Pre-lodgement Meeting Notes

Application No:	PLM2025/0065
Meeting Date:	3 June 2025
Property Address:	36 Cabbage Tree Road BAYVIEW
Proposal:	Demolition works and construction of a residential care facility
Attendees for Council:	Nick Keeler, Planner Daniel Milliken, Manager Development Advisory Service Catriona Alder, Waste Planning and Compliance Officer David Hellot, Senior Environment Officer - Catchments Belinda Morgan, Acting Senior Environment Officer - Catchments Dominic Chung, Senior Urban Designer Finola Sturrock, Senior Urban Designer
Attendees for applicant:	Chris Forrester Sarah Castro Corey Taylor Tyron Nicholson Harry Bate Lara Caulder Bradley Wahl

SITE PLAN

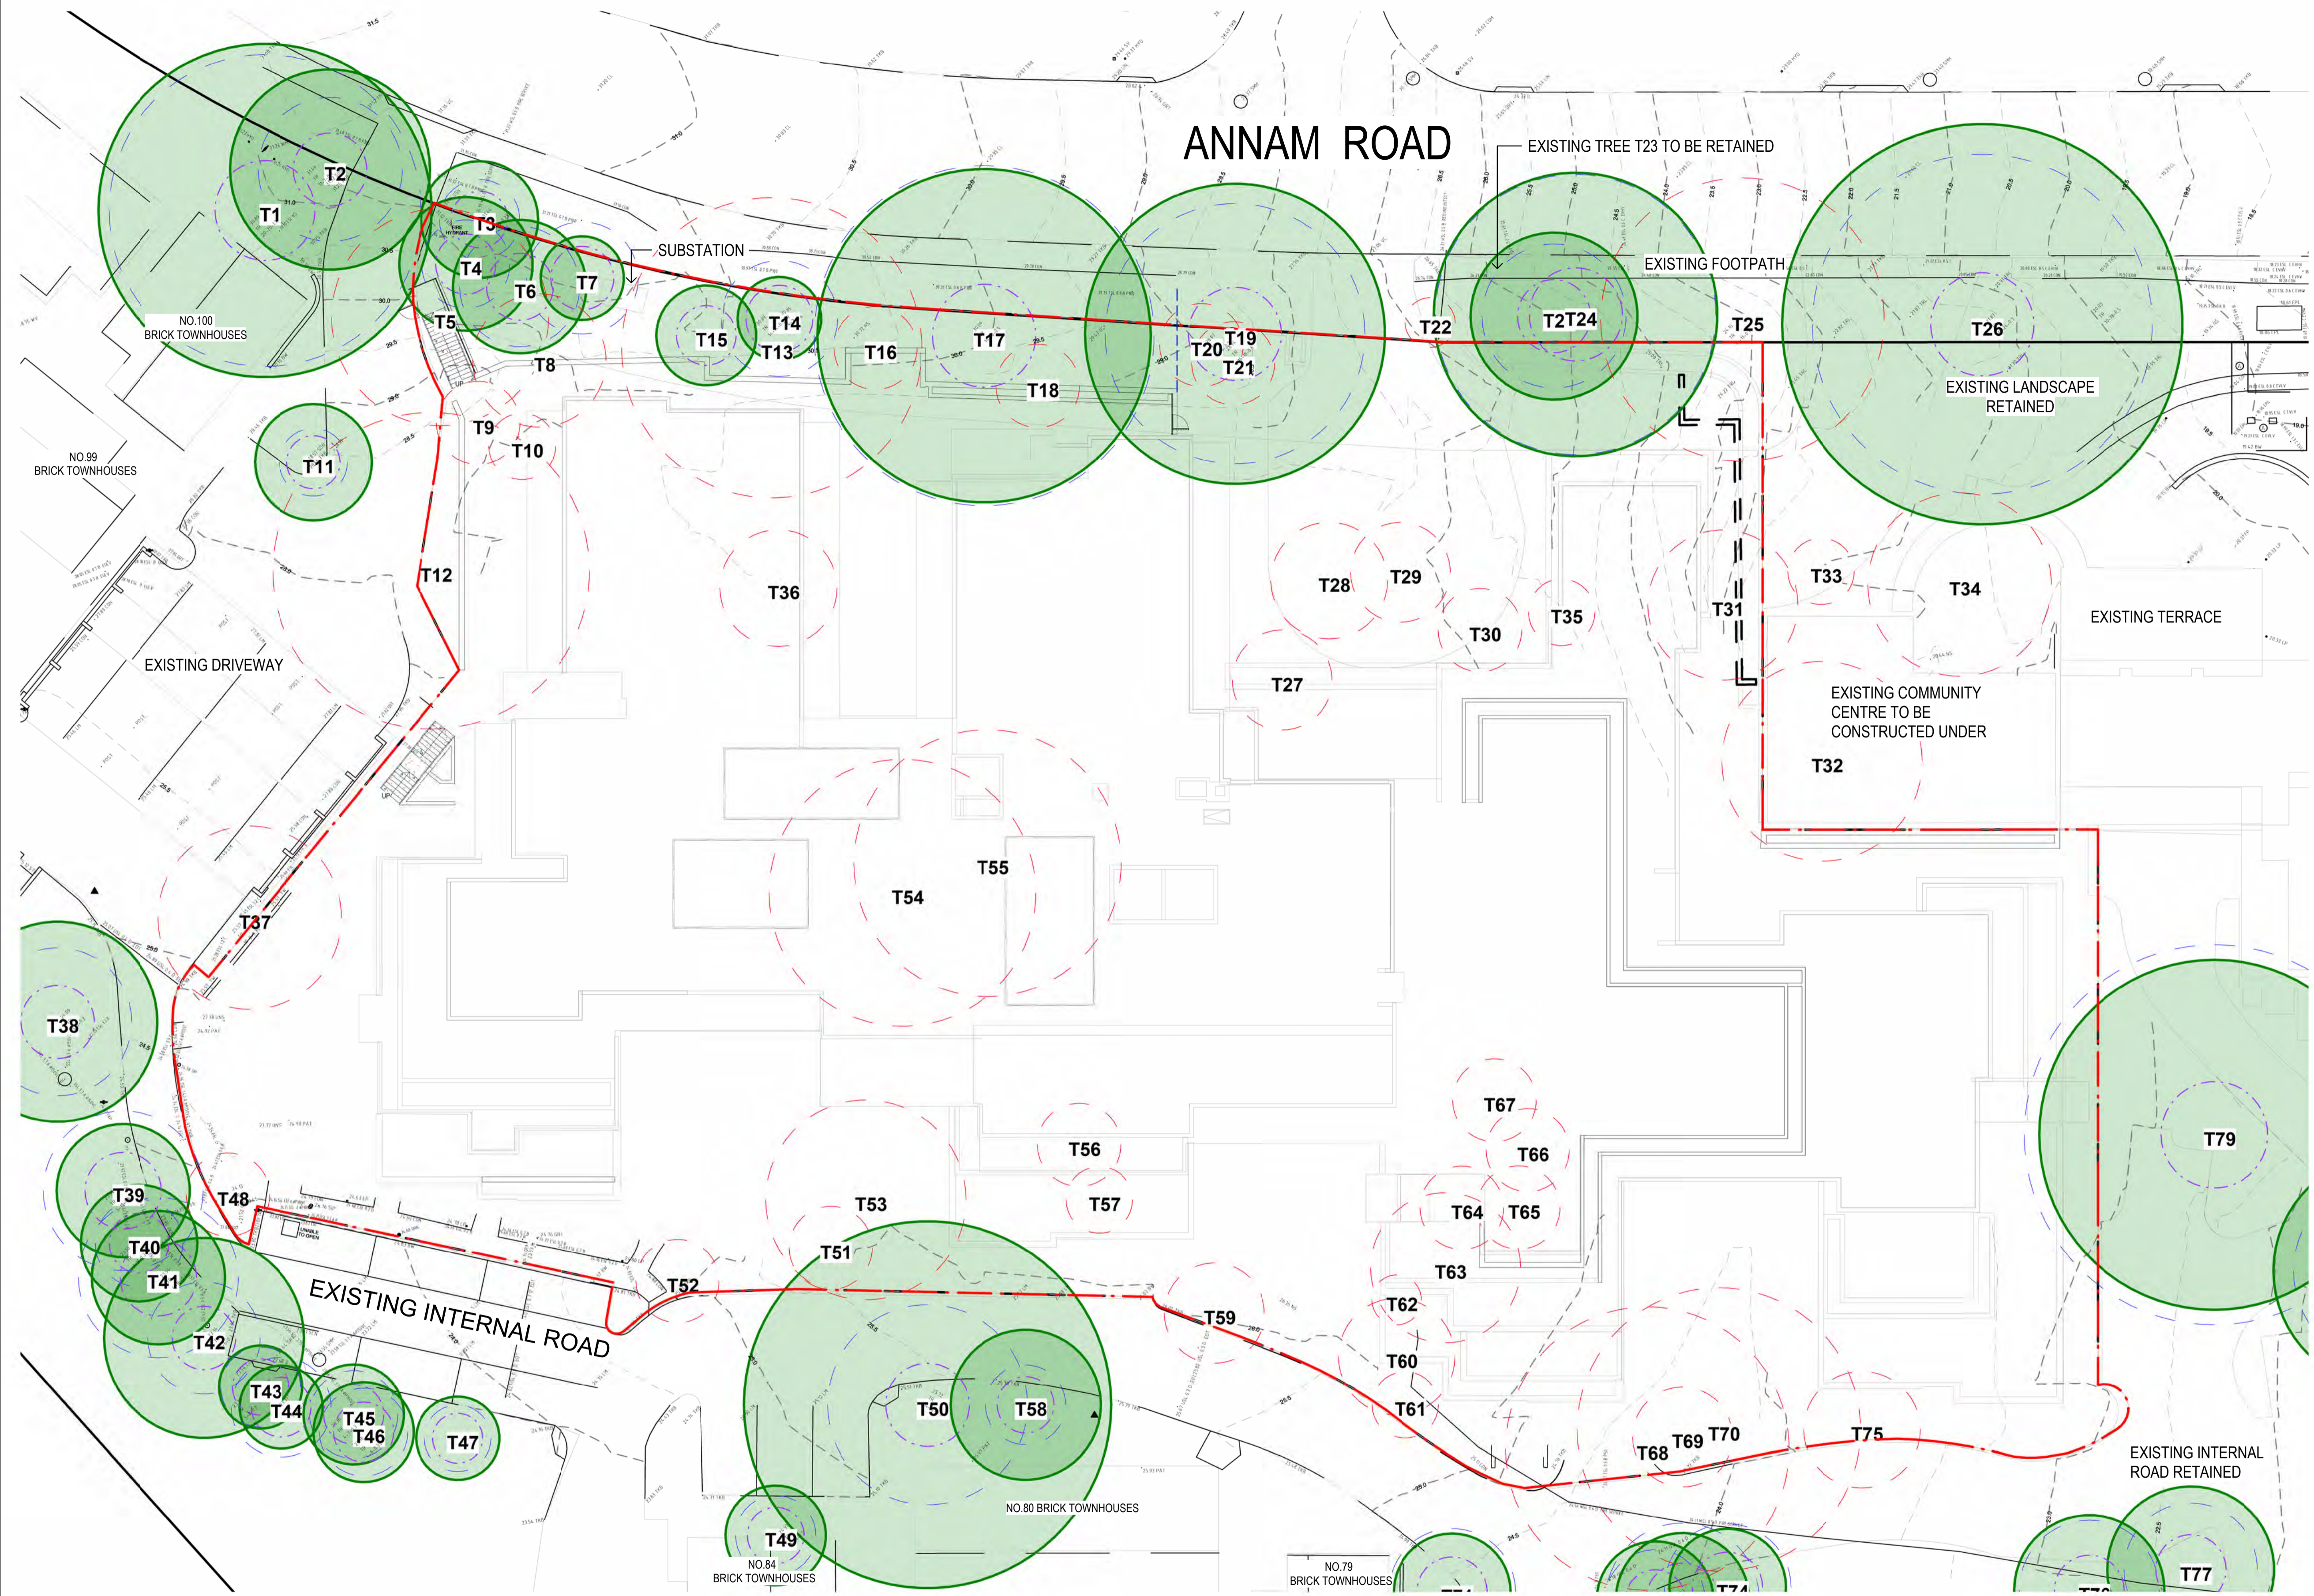
3. To achieve this the existing trees within the road reserve verge and within the property shall be preserved and the concept plans appear to indicate this to some extent. However, this is not easily assessed with the concept plans presented and without Survey information to determine the impact of any excavation, and an Arborist Report investigation is necessary to identify the impacts of the development upon existing trees.
